**Re: Take 5 Oil Change at 2030 Gibson Blvd SE
Erosion and Sediment Control Plan
Engineer's Stamp Date – 1/14/26 - M15E021E – (SWQ-2026-00003)**

Based upon the information provided in your submittal received 1/14/2026, the above-referenced ESC Plan cannot be approved until the following comments are addressed.

DESIGN REVIEW COMMITTEE CITY ENGINEER APPROVAL ZONE MAP NO. M-15 & L-15
CITY PROJECT NO.
SHEET NO. **C3.1**
PAGE 2 OF 4

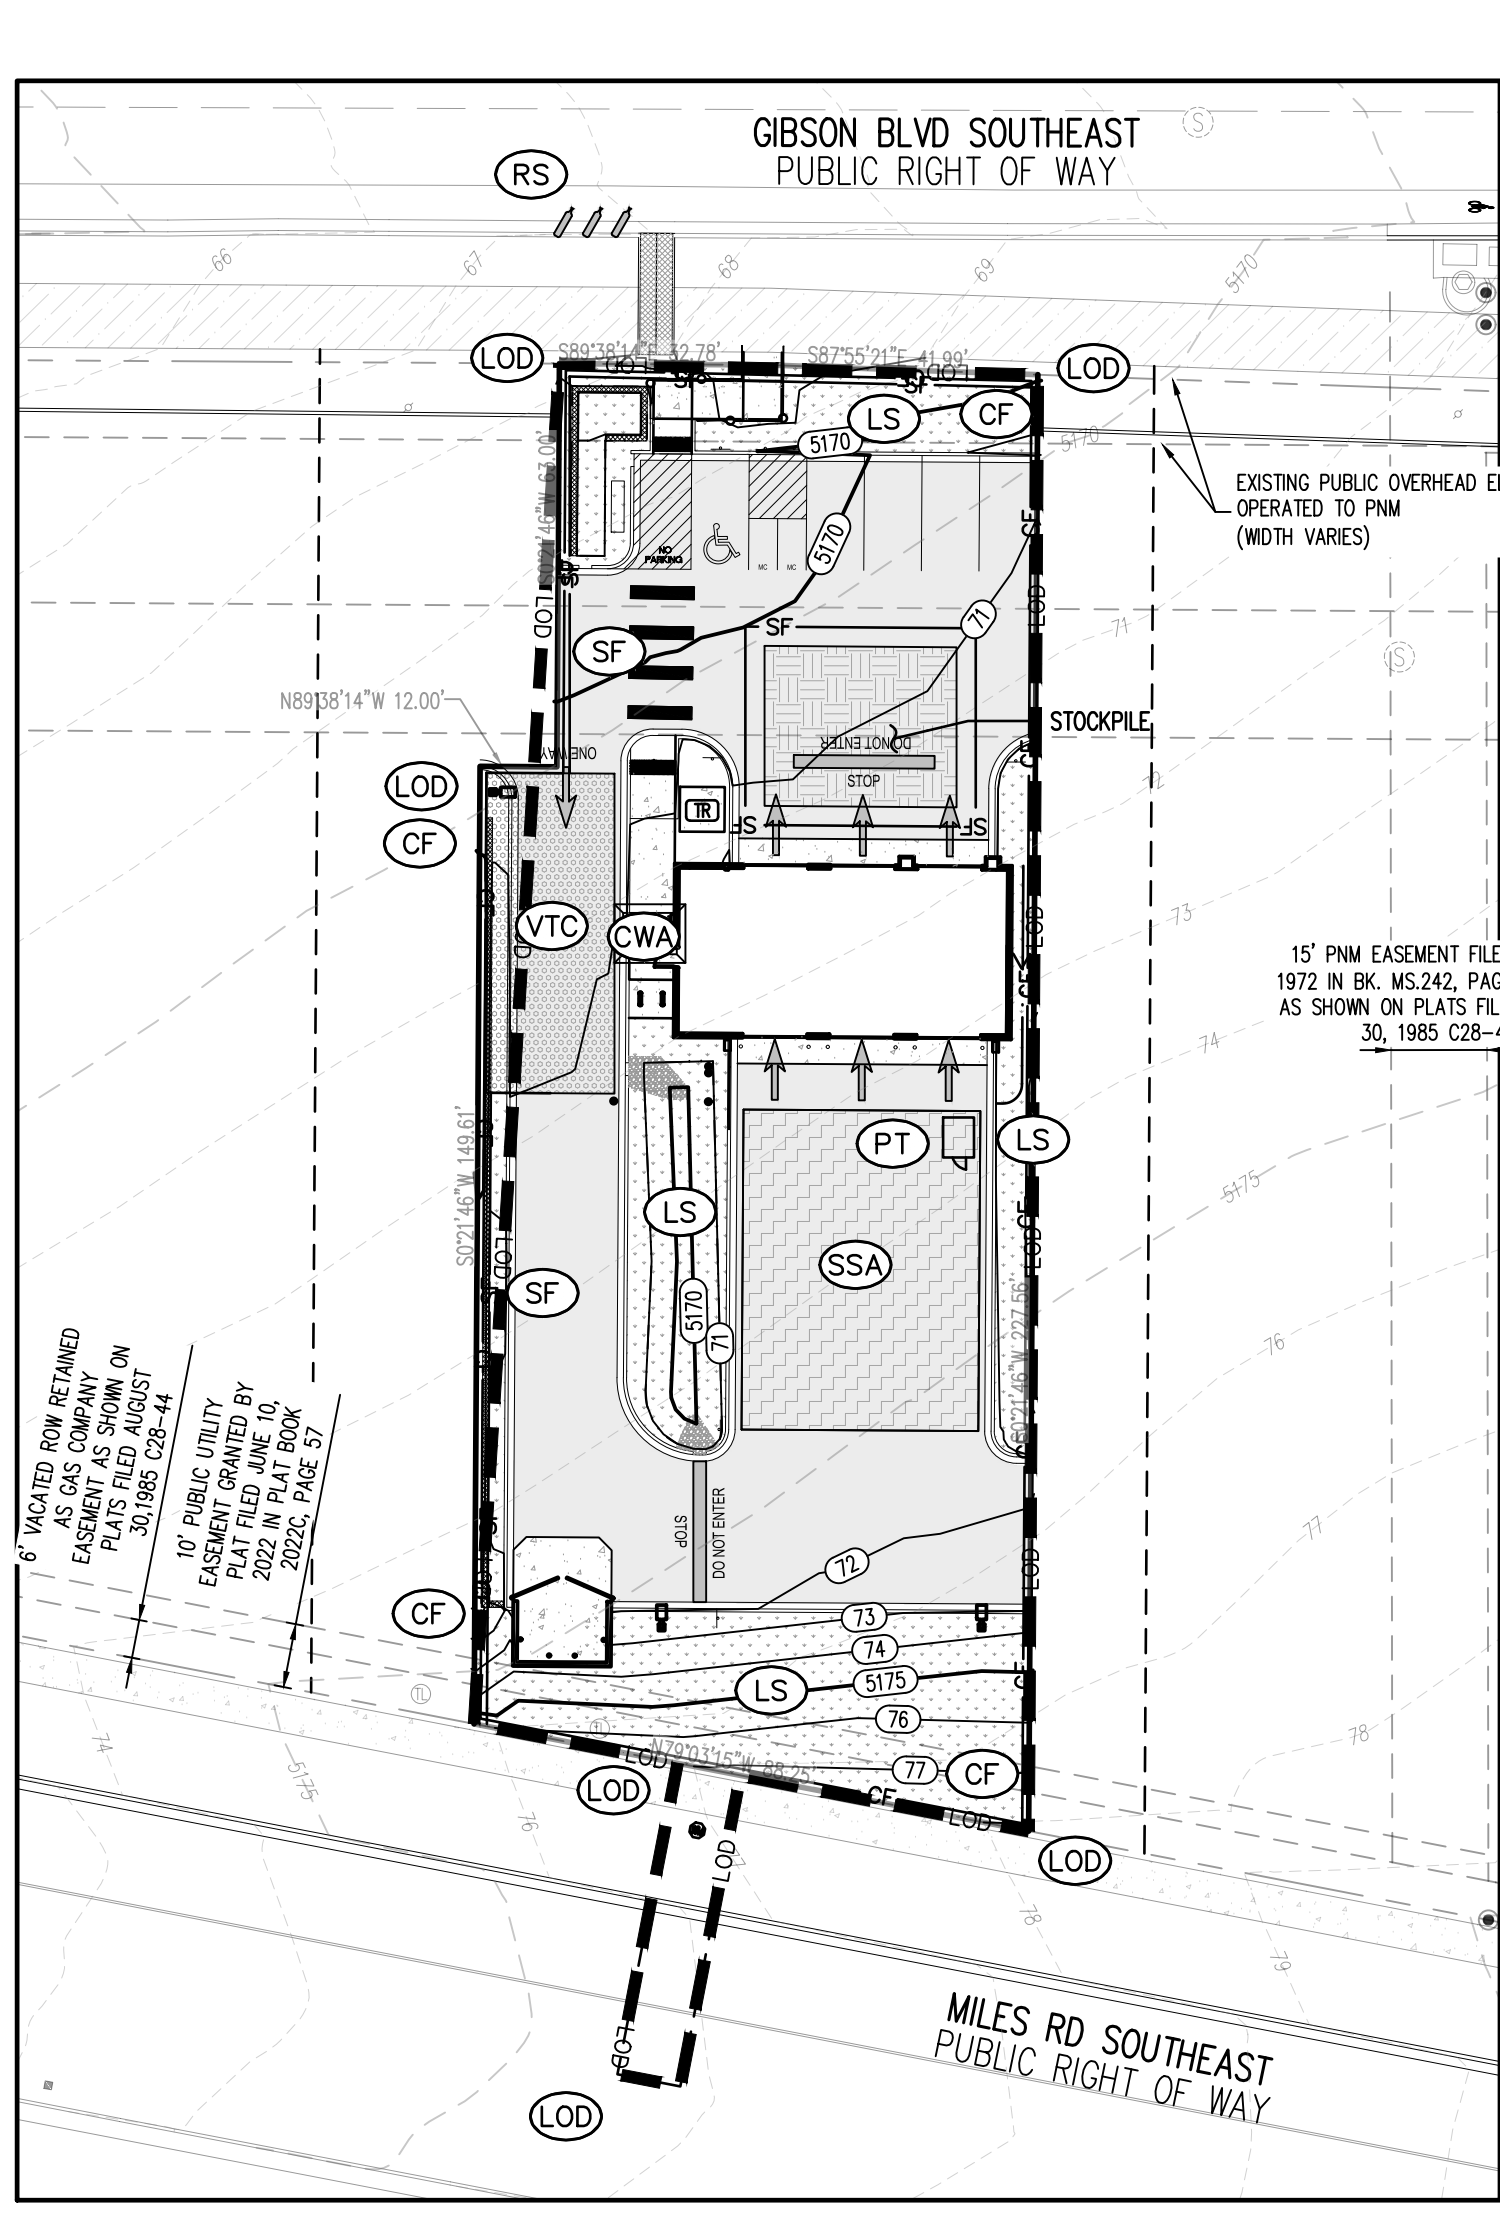
2. The notes on sheet C1.3 are in error where it says "Existing site runoff discharges through sidewalk culverts into Gibson Blvd." A second Discharge Point goes west into Lot B. Identify both Discharge points on the ESC Plan.

3. The notes on sheet C1.3 are further in error where it says, "Offsite flows don't enter the project site." The off-site areas were previously identified on sheet DR-1 of the approved G&D Plan. Correct the note and identify the off-site drainage areas and their discharge points into this property on a drainage area map as one of the sheets in this ESC Plan.

4. Temporary sediment traps must be constructed upstream of the onsite discharge points as one of the first items of construction, at the same time as the existing pavement demolition. The required size of the temporary sediment traps is based on the entire area, onsite and off-site, that drains to each trap. Include design calculations, construction details, and specifications for the temporary sediment traps in accordance with CGP 2.2.12 in the ESC Plan resubmittal. Add the sediment traps construction as the first item in the sequence of construction, and its removal as the last item after the rest of the site is constructed and stabilized. Sediment traps may have to overlap into the parking lot.

5. Provide Diversion Channels along the low side of the site to direct stormwater into the Sediment traps.
6. The existing and proposed drainage patterns are not adequately defined. Show the existing grades on the west and east sides of this site, where adjacent development has cut channels and slopes into this site. Identify proposed concentrated flow paths on-site and add spot elevations.

LOVELACE HEIGHTS ADDITION CITY OF ALBUQUERQUE 2030 GIBSON BOULEVARD	
EROSION CONTROL DETAILS	
DESIGN REVIEW COMMITTEE	CITY ENGINEER APPROVAL
ZONE MAP NO. M-15 & L-15	
CITY PROJECT NO.	
SHEET NO. C3.2	
PAGE 3 OF 4

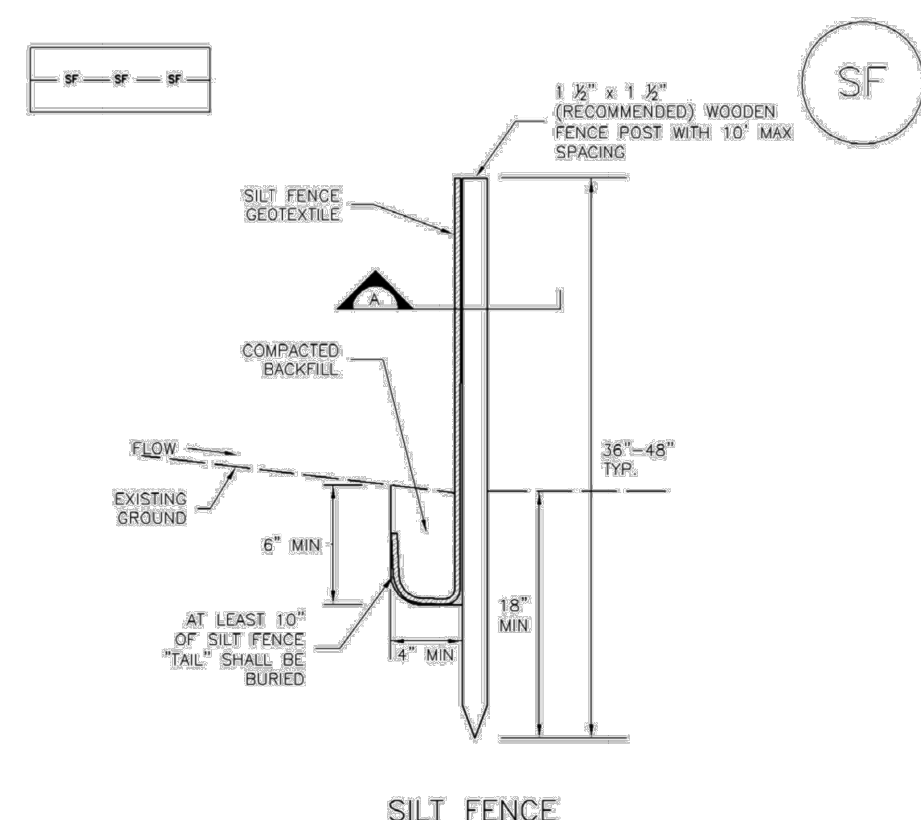
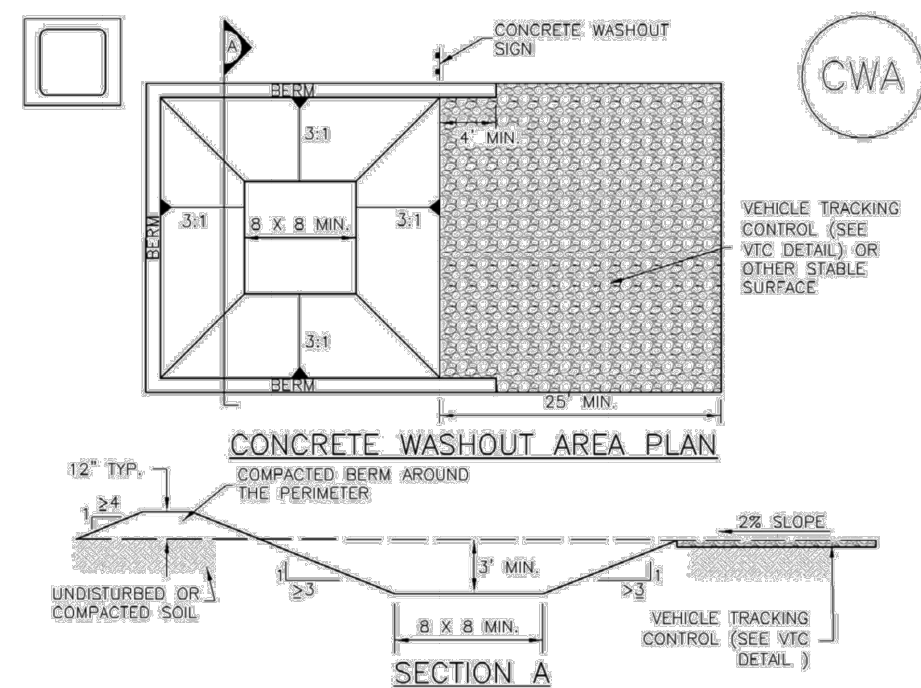
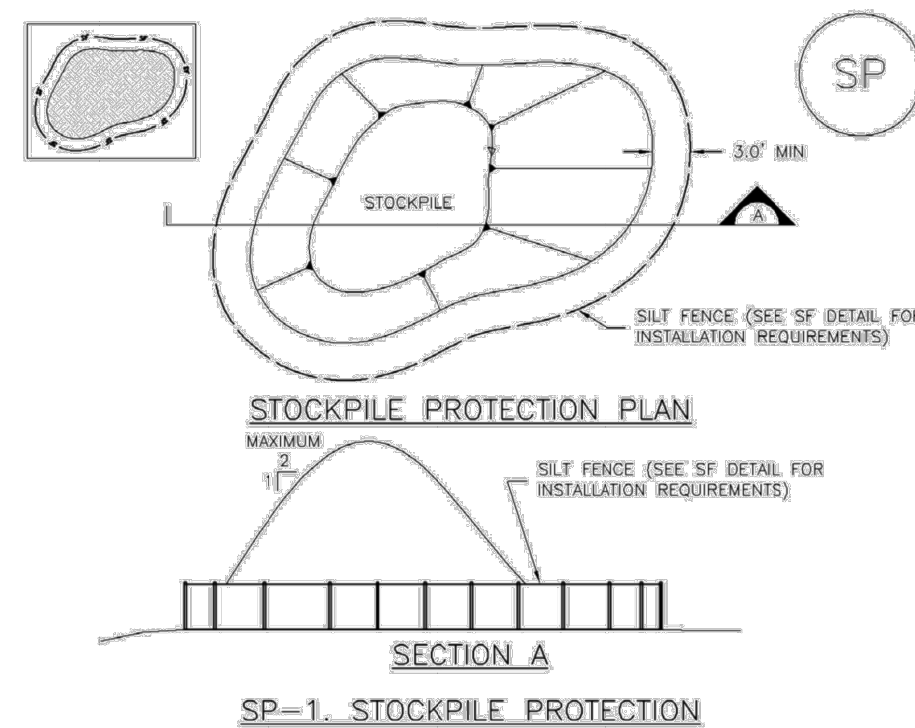
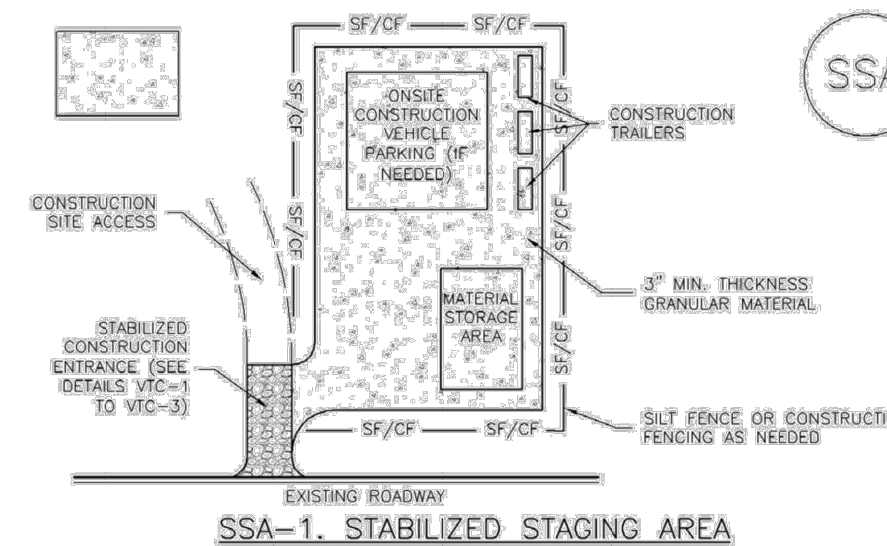
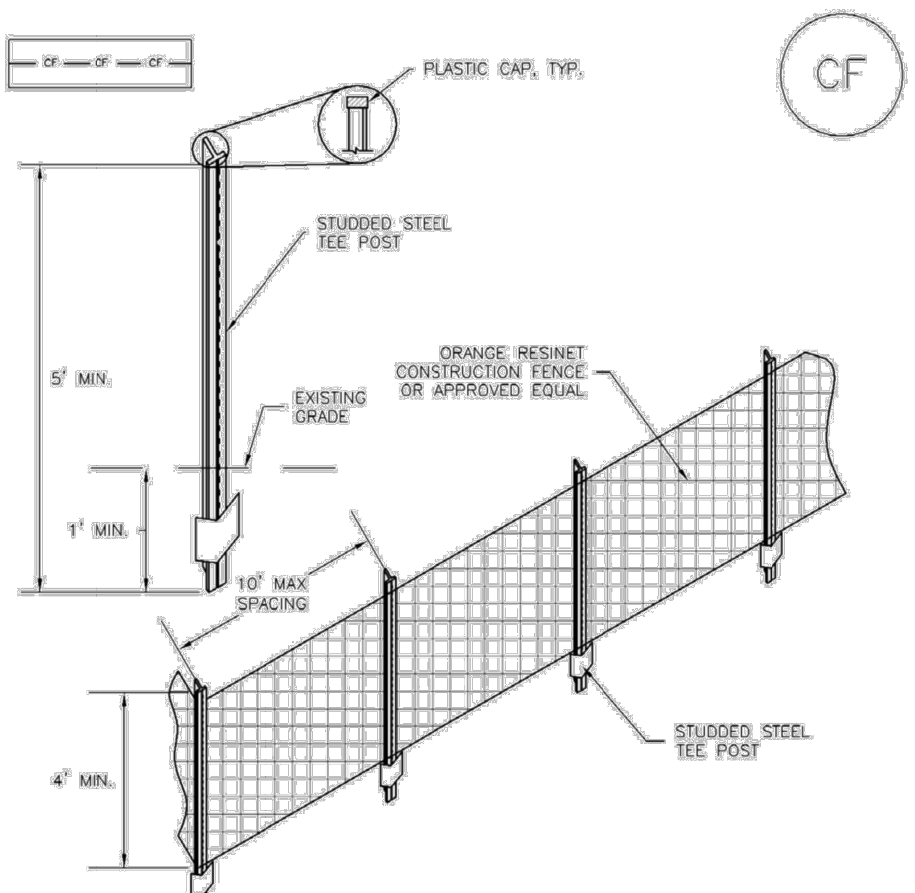
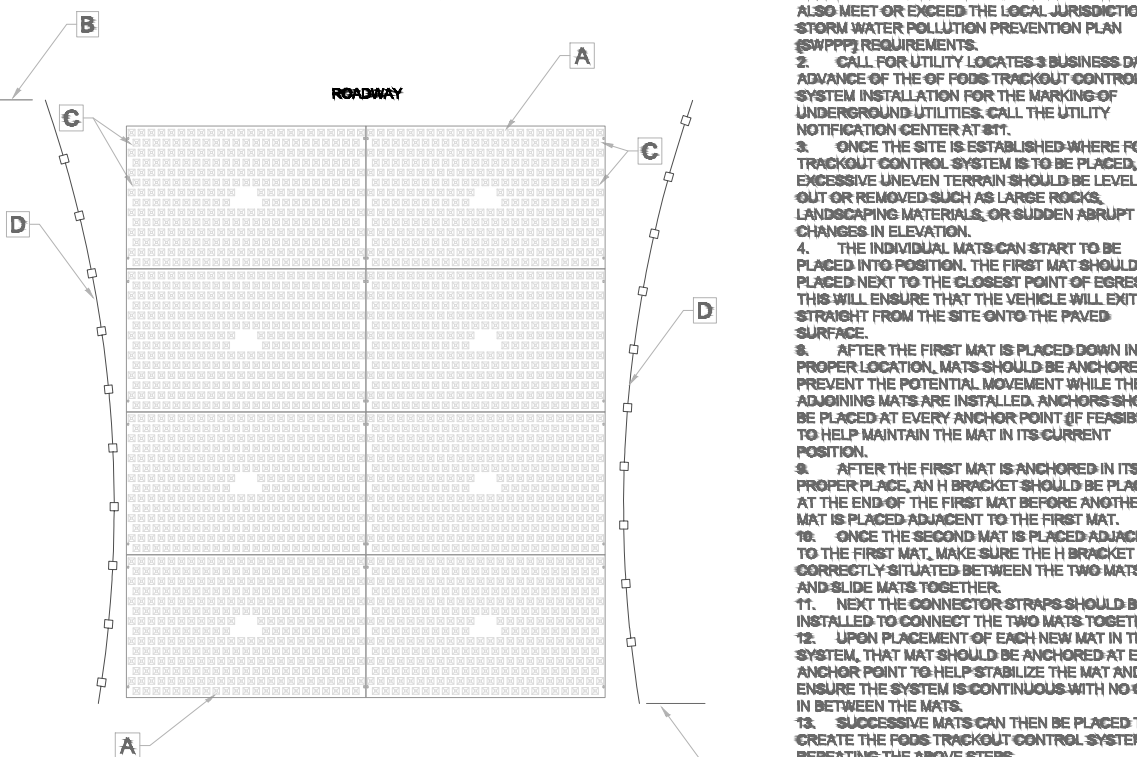
7. The text on the details sheets C3.2 and C3.3 is blurred and illegible.
8. Soil information – add a table with name type, particle sizes, and Erodibility factor (CGP 2.1.1).
